Meeting note

Project name	Norfolk Boreas
File reference	EN010087
Status	Final
Author	The Planning Inspectorate
Date	8 February 2019
Meeting with	Norfolk Boreas Limited
Venue	Temple Quay House
Meeting objectives	Draft documents review meeting
Circulation	All attendees

Norfolk Boreas: Planning Inspectorate's comments on draft Plans

Doc Ref: 2.2	APFP Ref: 5(2)(i)	Drawing No: 006_ARDG_Norfolk_B_LP_S140a42a_Rev6			
Revision: 00	Date: 29/04/2019	Drawn: IM	Checked: AP	Size: A1	Scale: 1:2,500

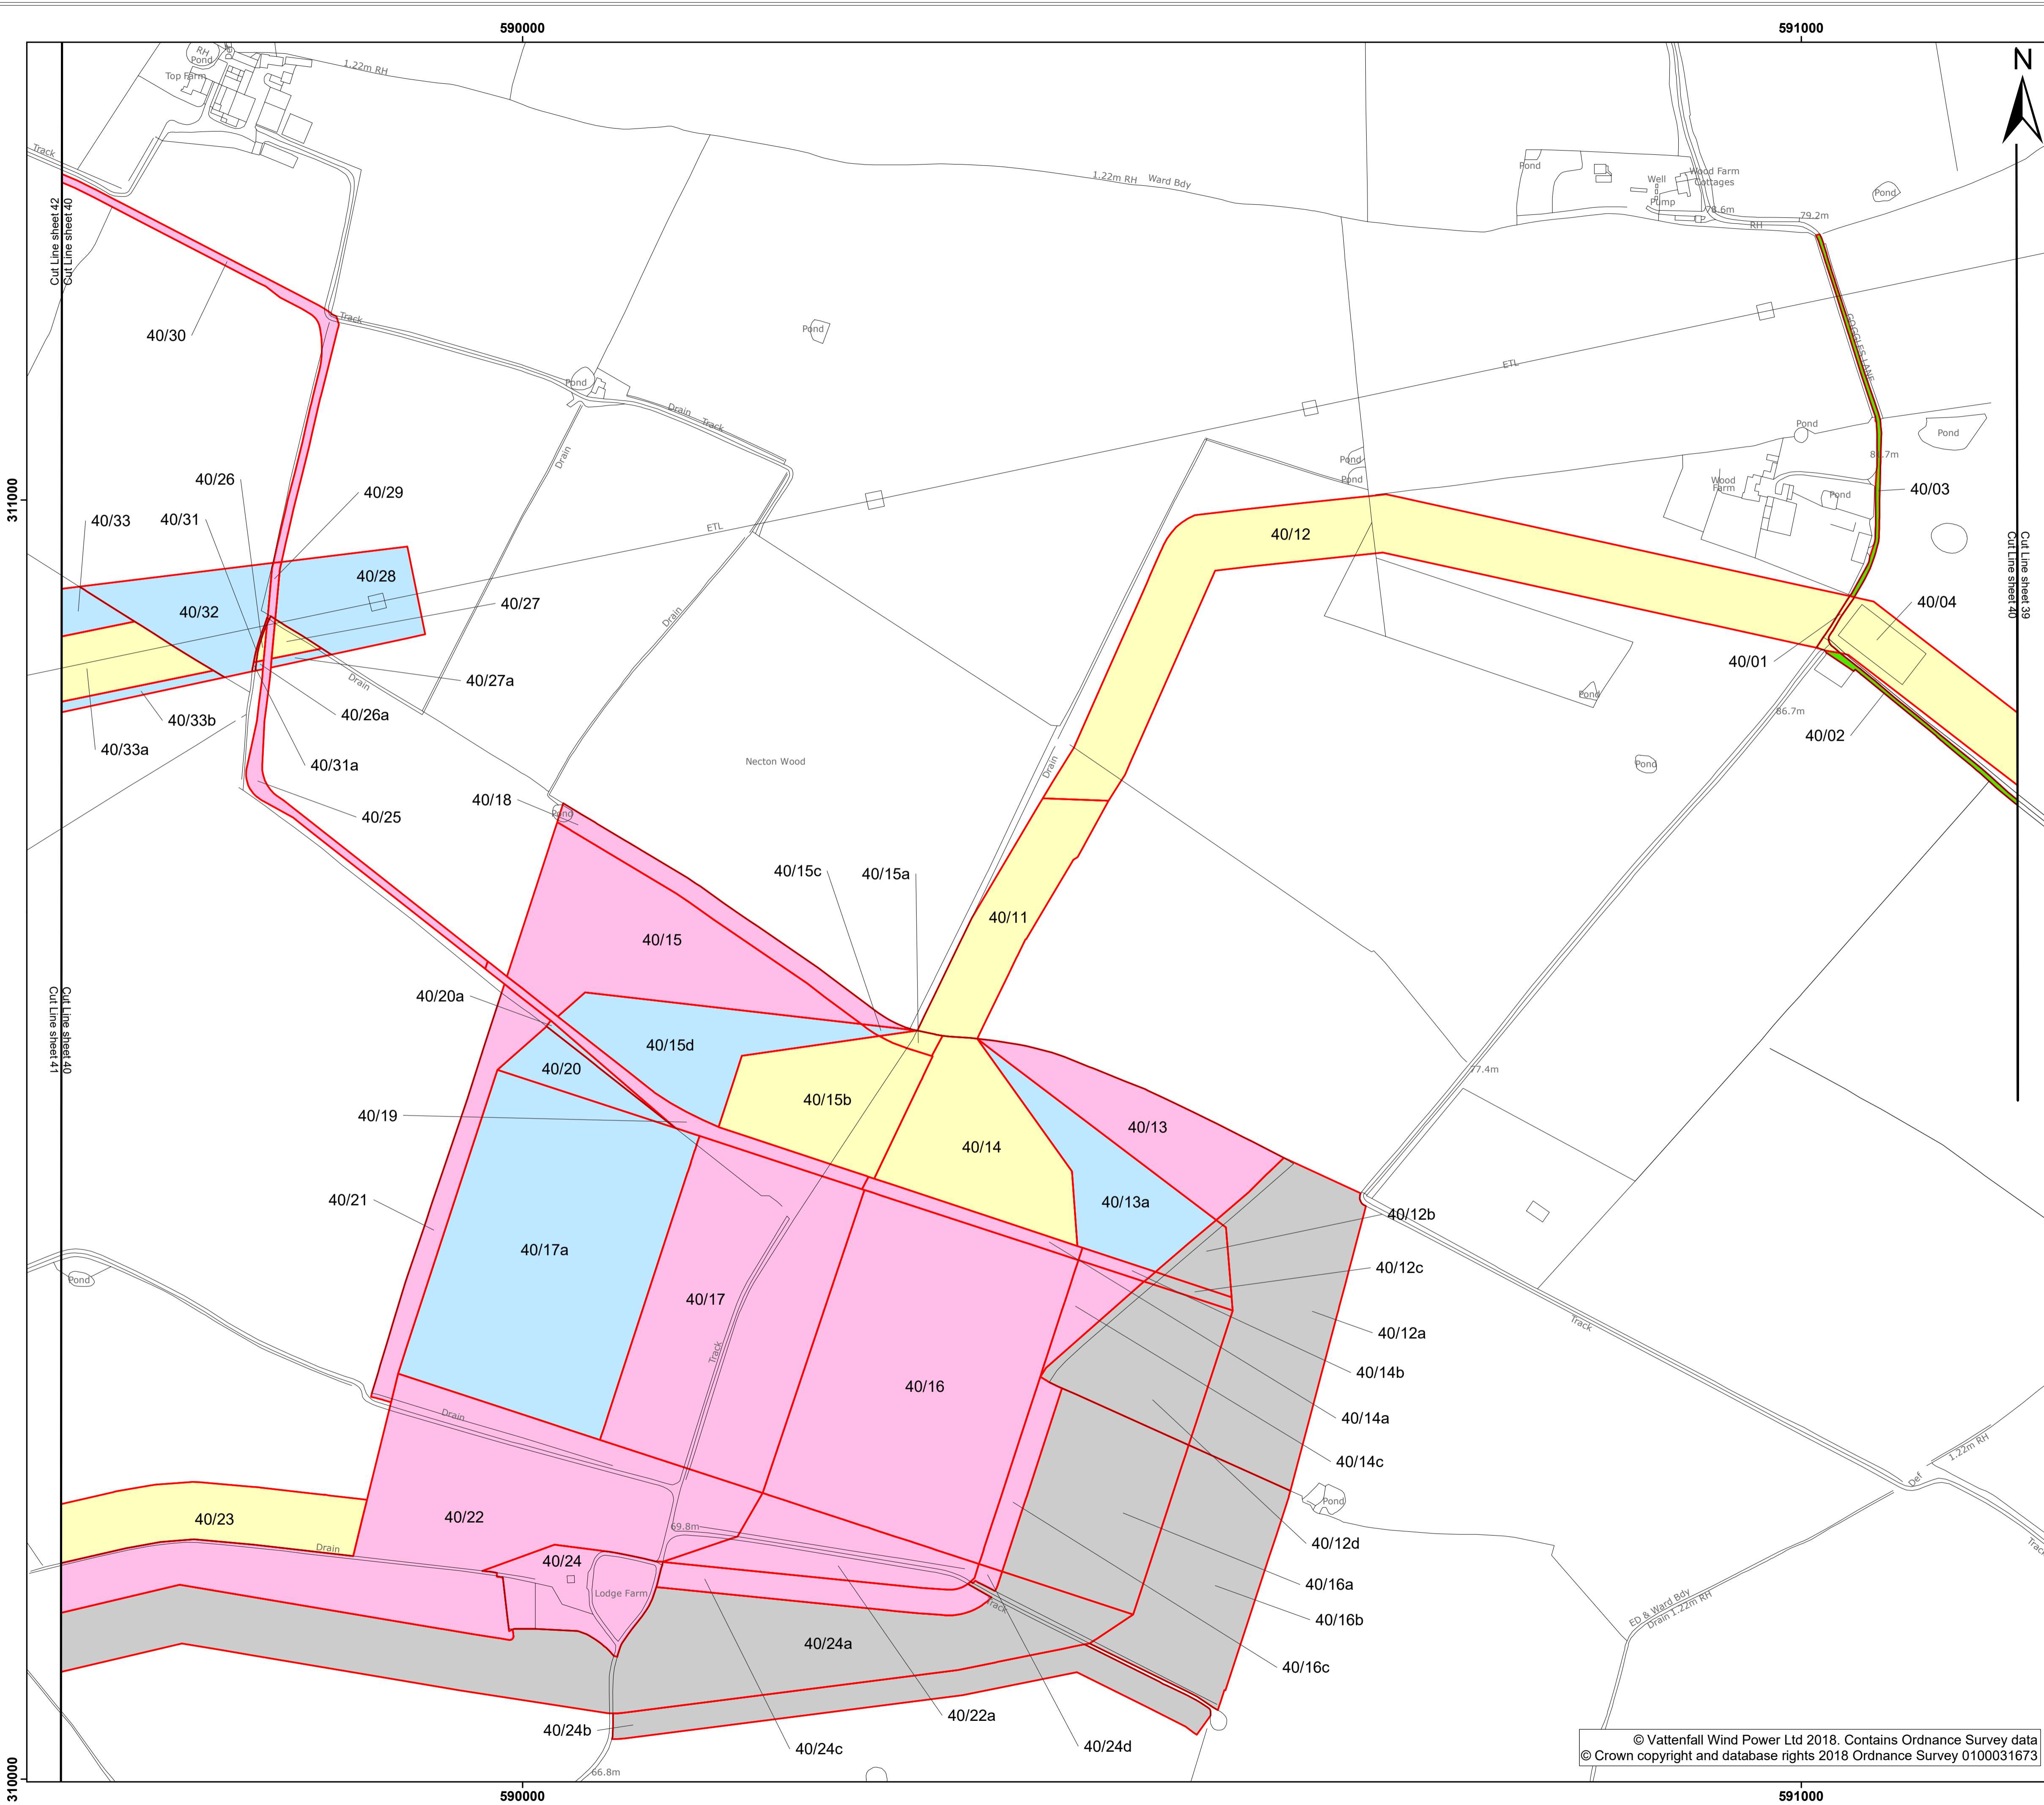
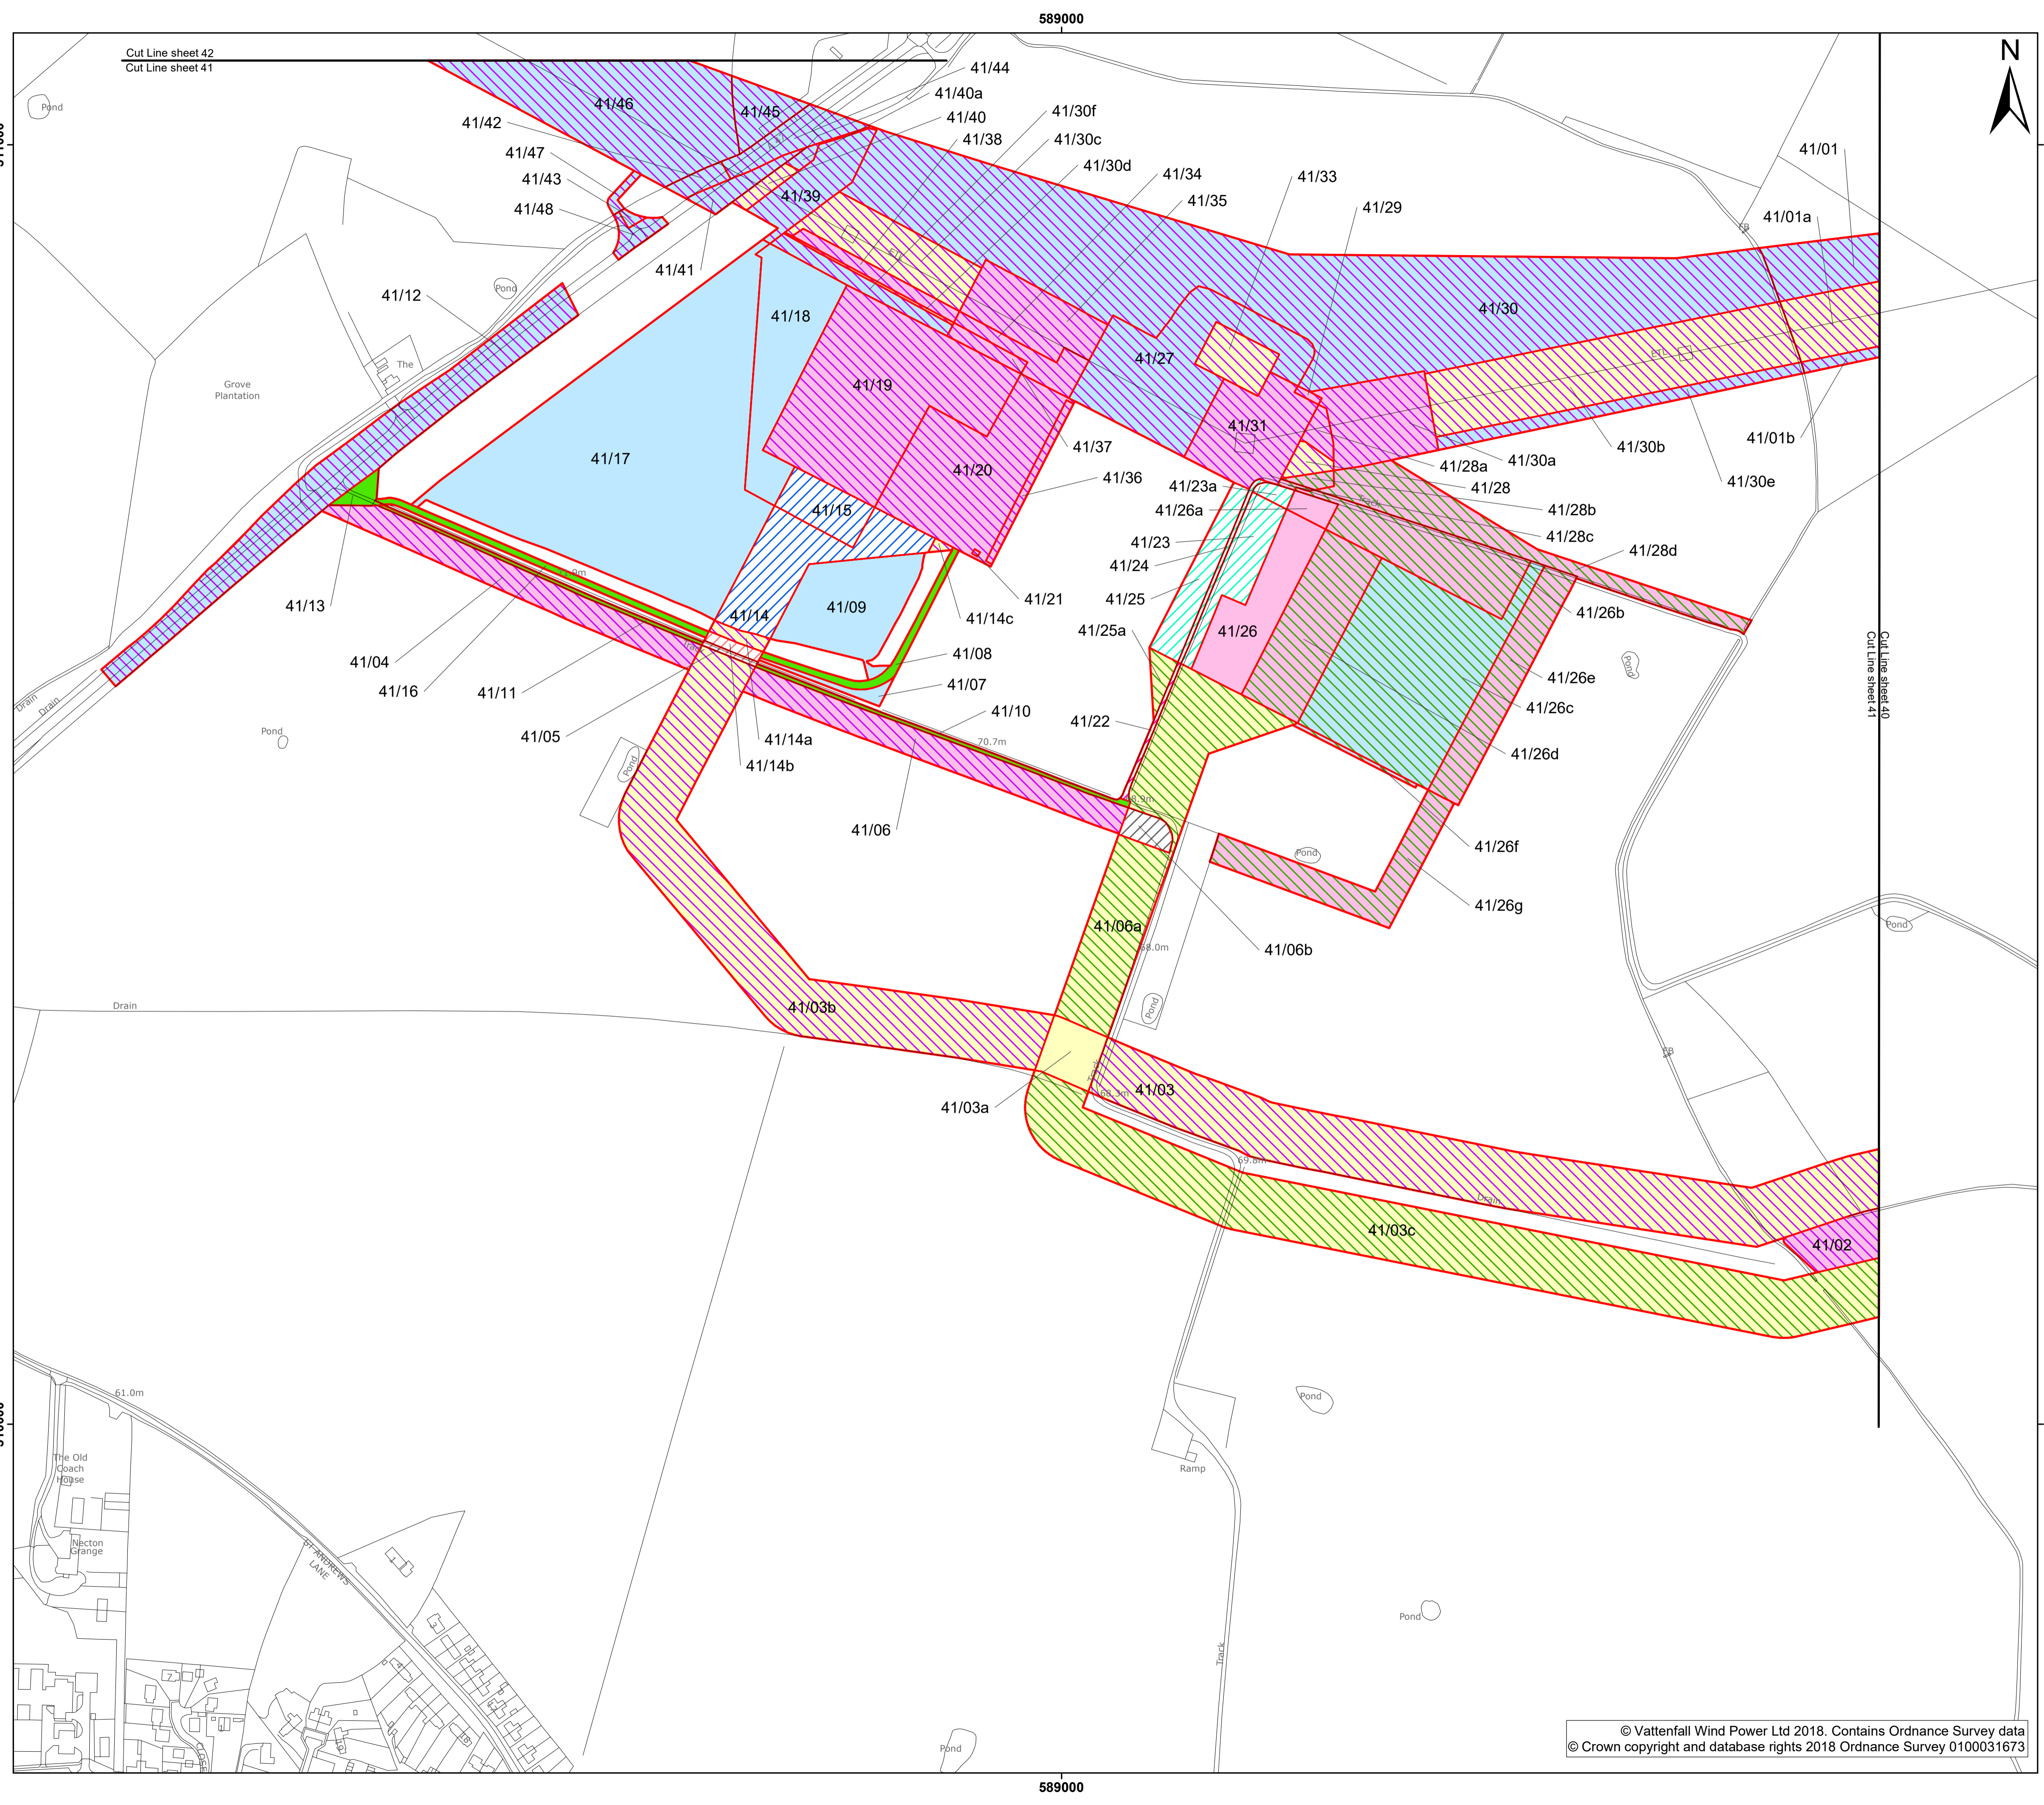
Land Plan	The plot boundaries and numbering are clear and easy to understand. As we have not received a more evolved DCO, it isn't possible to ascertain if the shading used is consistent.
Land Plans	It is noted that the plans are reasonably complicated and that it should be clear to all stakeholders, especially those with an interest in land, what powers are sought for any given plot. The applicant should ensure that the references to the plans in the DCO and all documentation correspond exactly with the headings on the land plans themselves.
Land Plans	The Applicant should pay particular attention to plots where the use of land can differ depending on whether scenario 1 or 2 is implemented.
Land Plans	Within the key for this plan, it would be beneficial if there was further explanation in the definitions to

(Sheet 40)	explain what rights were being sought for which scenario (and also what rights were being sought in both scenarios. If there was any extinguishment of rights being sought these should also be clearly labelled in the key and set out in the plans.
Land Plans (Interaction Plan)	<p>It is difficult to see some of the interactions of the two scenarios to the north of the substation, given the different, and number, of different shades used. Further clarity in this particular location should be considered.</p> <p>The plan should also clearly identify which of the attenuation ponds relate to which scenario.</p>
Work plans	The Applicant's approach to showing works for scenario 1 and 2 on separate plans, along with a composite plan showing both scenarios is helpful and greatly aids understanding.
Work Plans	Where land is only required for one scenario, the Applicant should be able to clearly demonstrate the need for the land in the DCO and may need to justify acquisition powers sought for land that may not be required in the final form of the scheme.
